MECKLENBURG COUNTY
Park and Recreation Department

MEMORANDUM

RE: Rezoning Petition #2021-101
PID# 19934202

**RZ - 1.0**

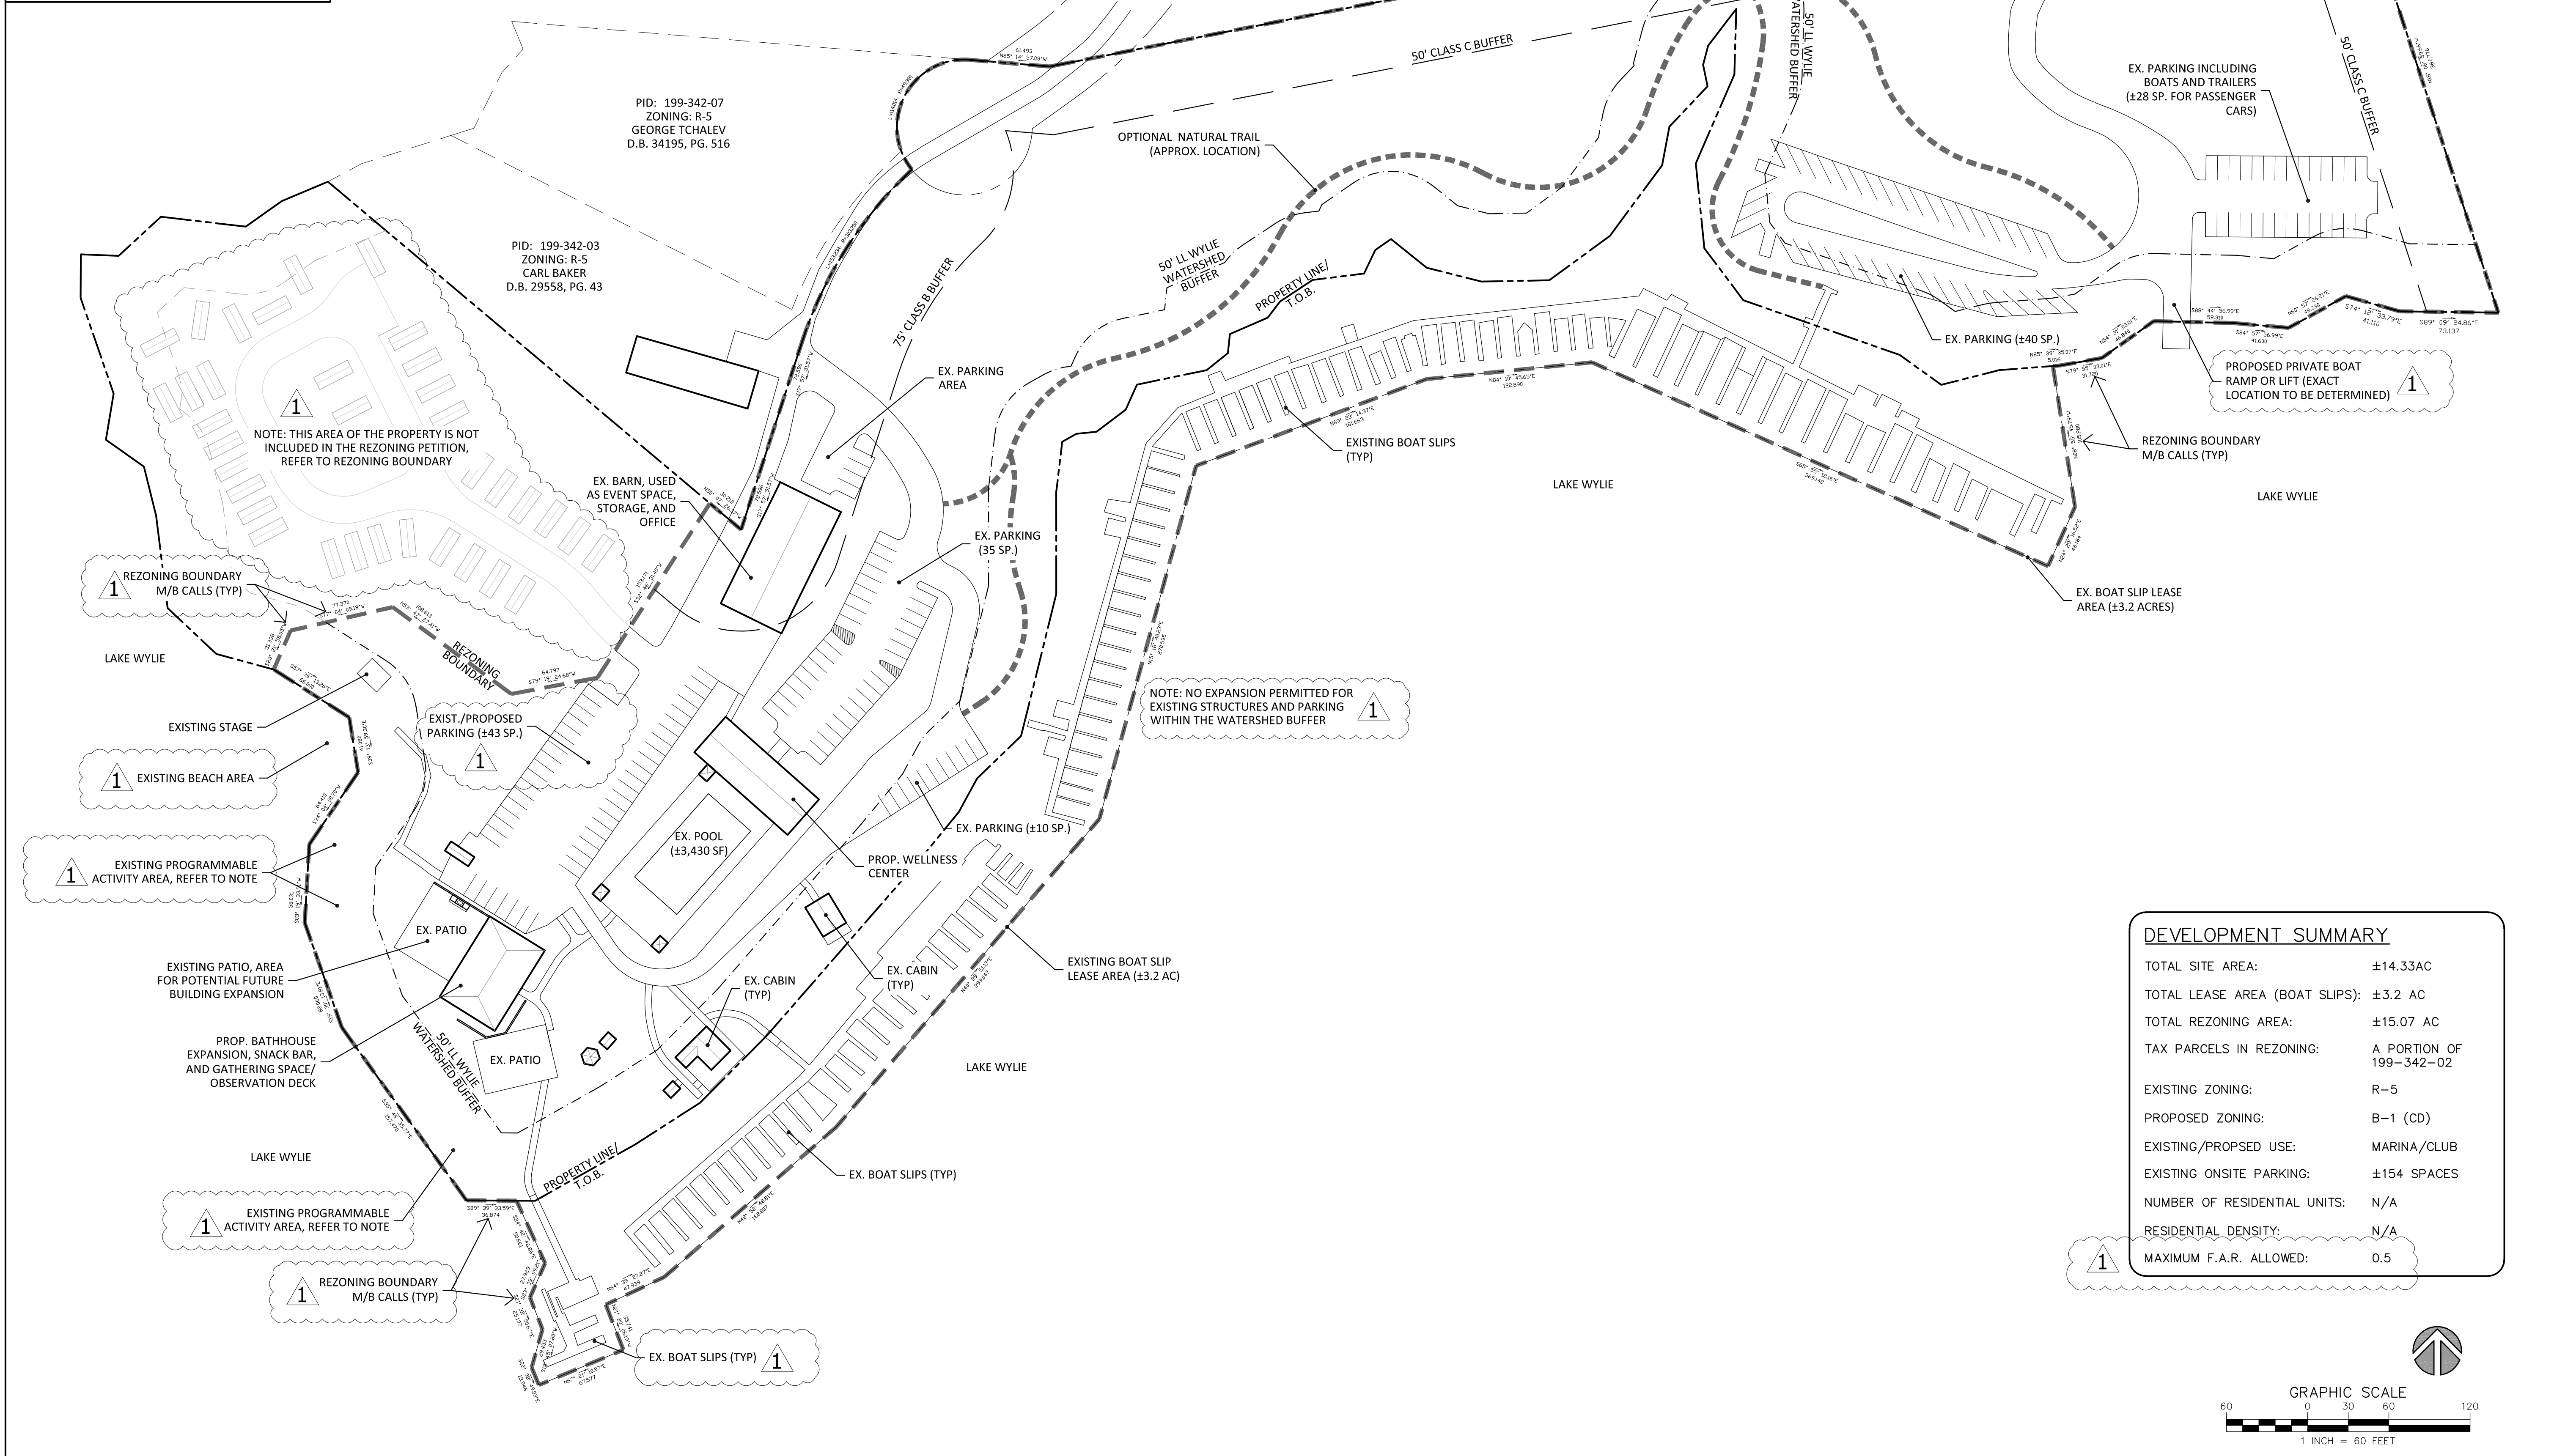
The existing access easement on Mecklenburg County property only allows for maintenance of the existing gravel driveway.
